## **Community Environment Network Inc.**

27<sup>th</sup> April 2021

### **Development Application for 89 John Whiteway Drive, Gosford (SSD 10321)**

This is a submission from the Community Environment Network regarding the development application for 89 John Whiteway Drive, Gosford. It is supplementary to our previous submission dated 20<sup>th</sup> May 2020.

Title
BLOCK B - WEST ELEVATION

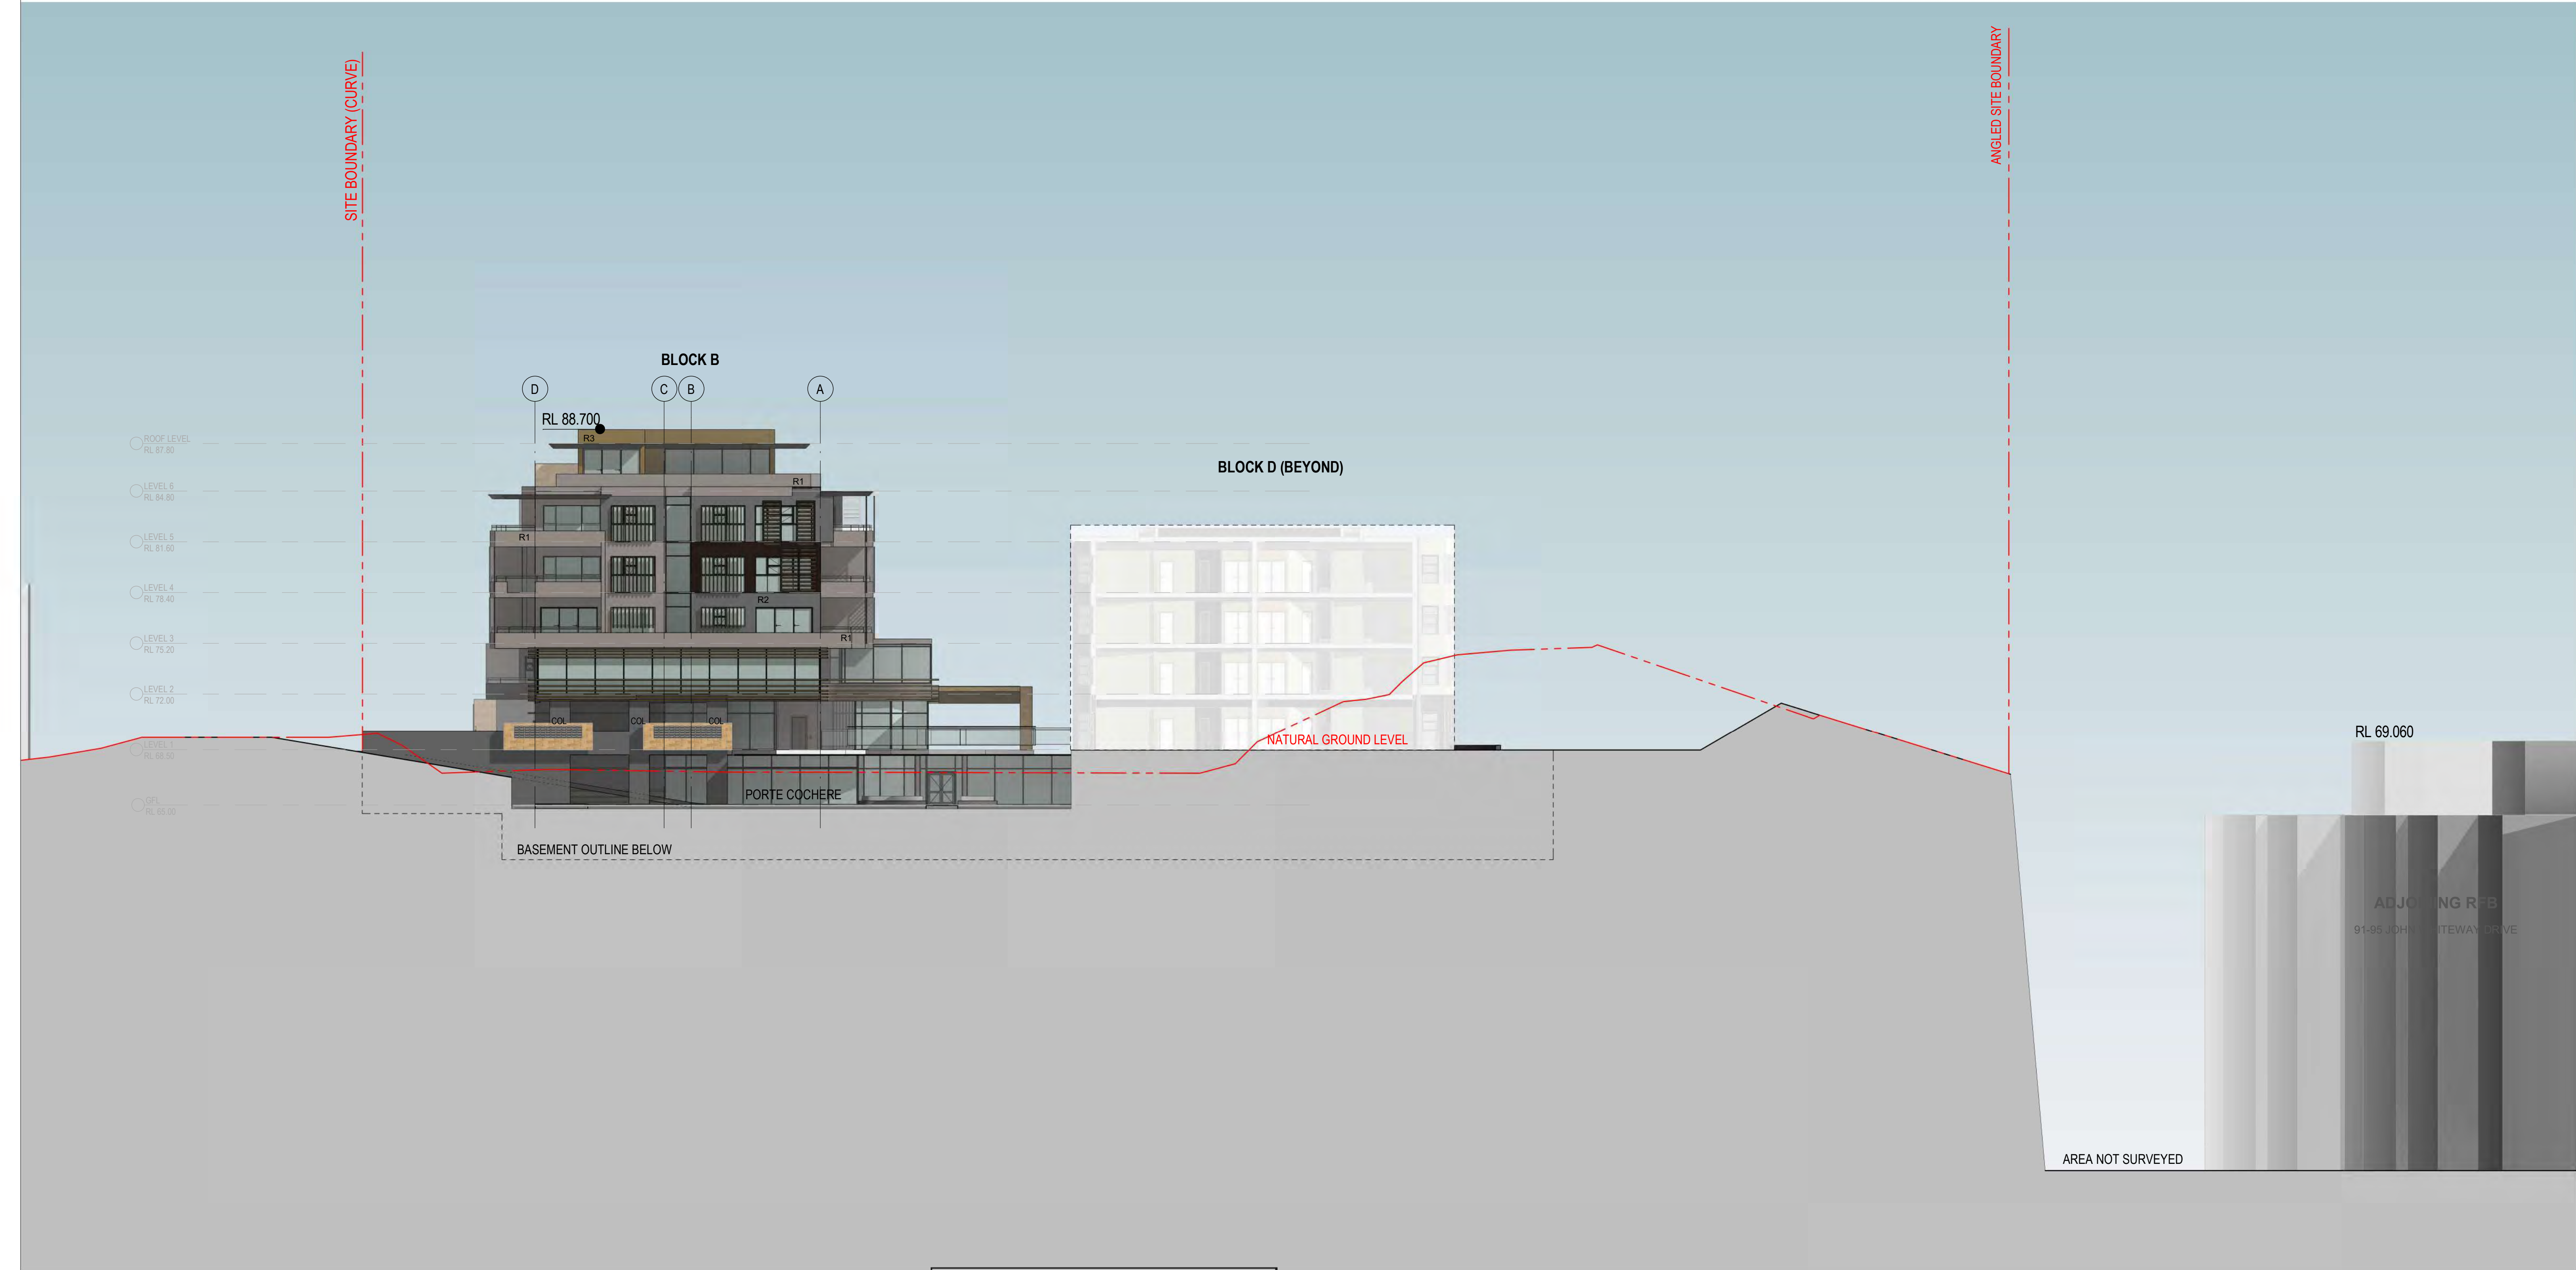
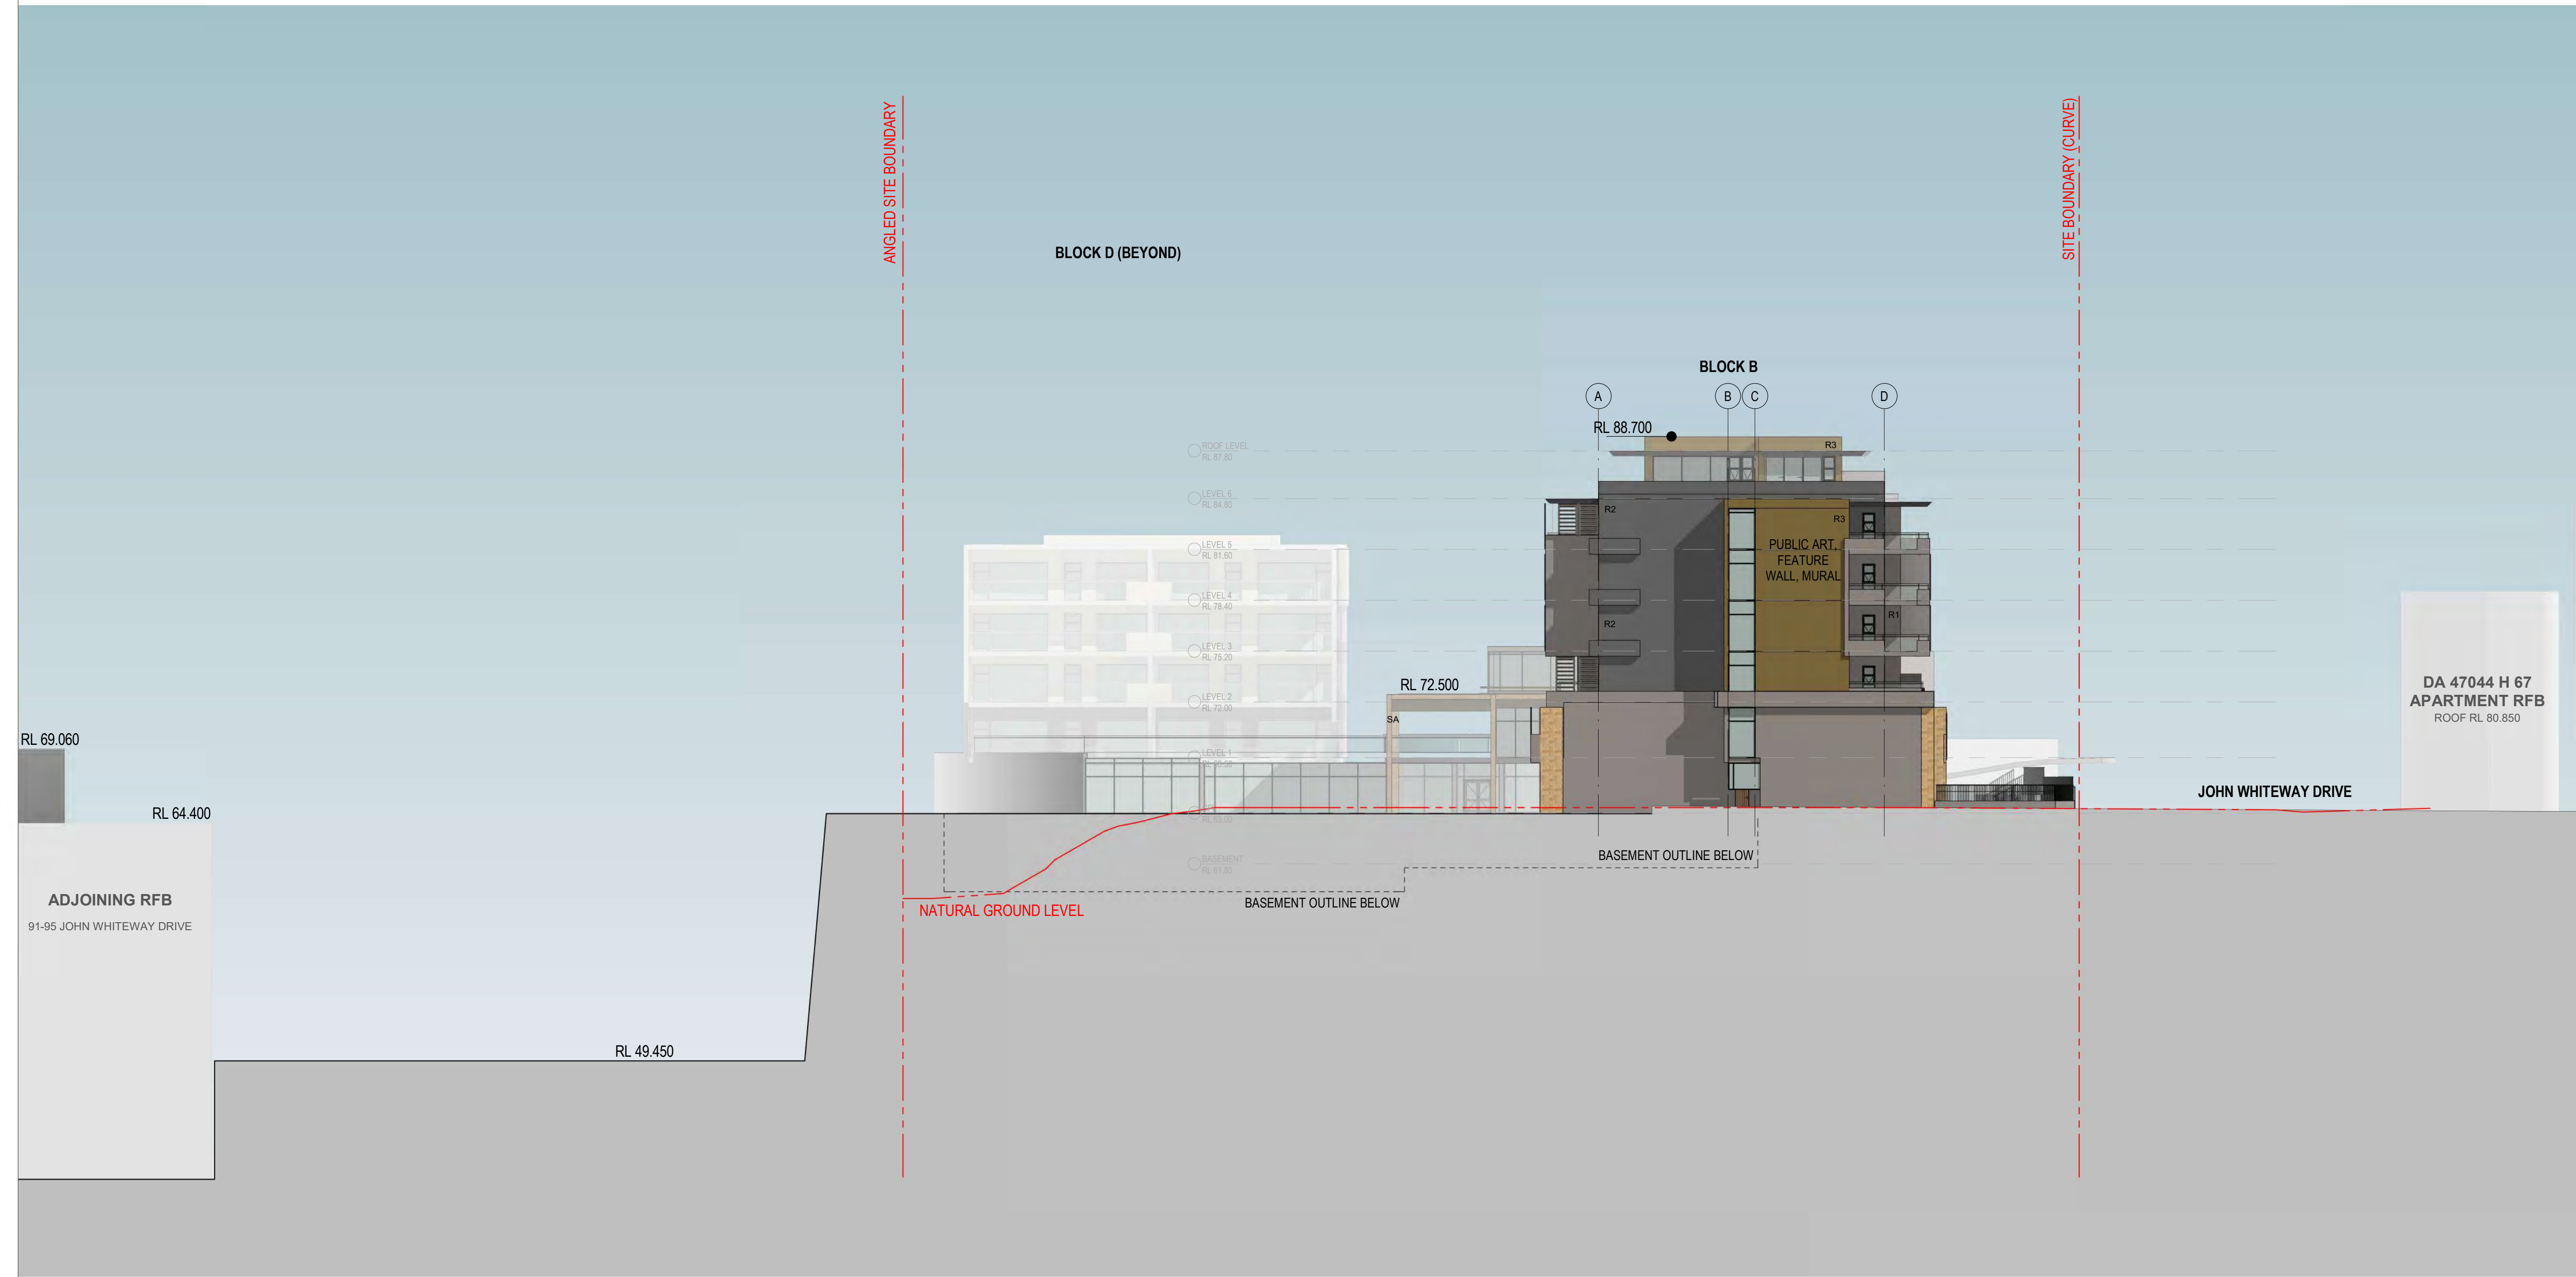
The revised version of the Clause 4.6 Variation Request now includes a more realistic calculation of the variation in the height limit (Table 1). However, there is a significant error in the calculation for Tower B because the proposed height of the tower is actually 22.68 metres, rather than 20.68 metres as indicated. Consequently, Table 1 should have indicated that the height of the southern wing of Tower B would exceed the height limit by 220%.
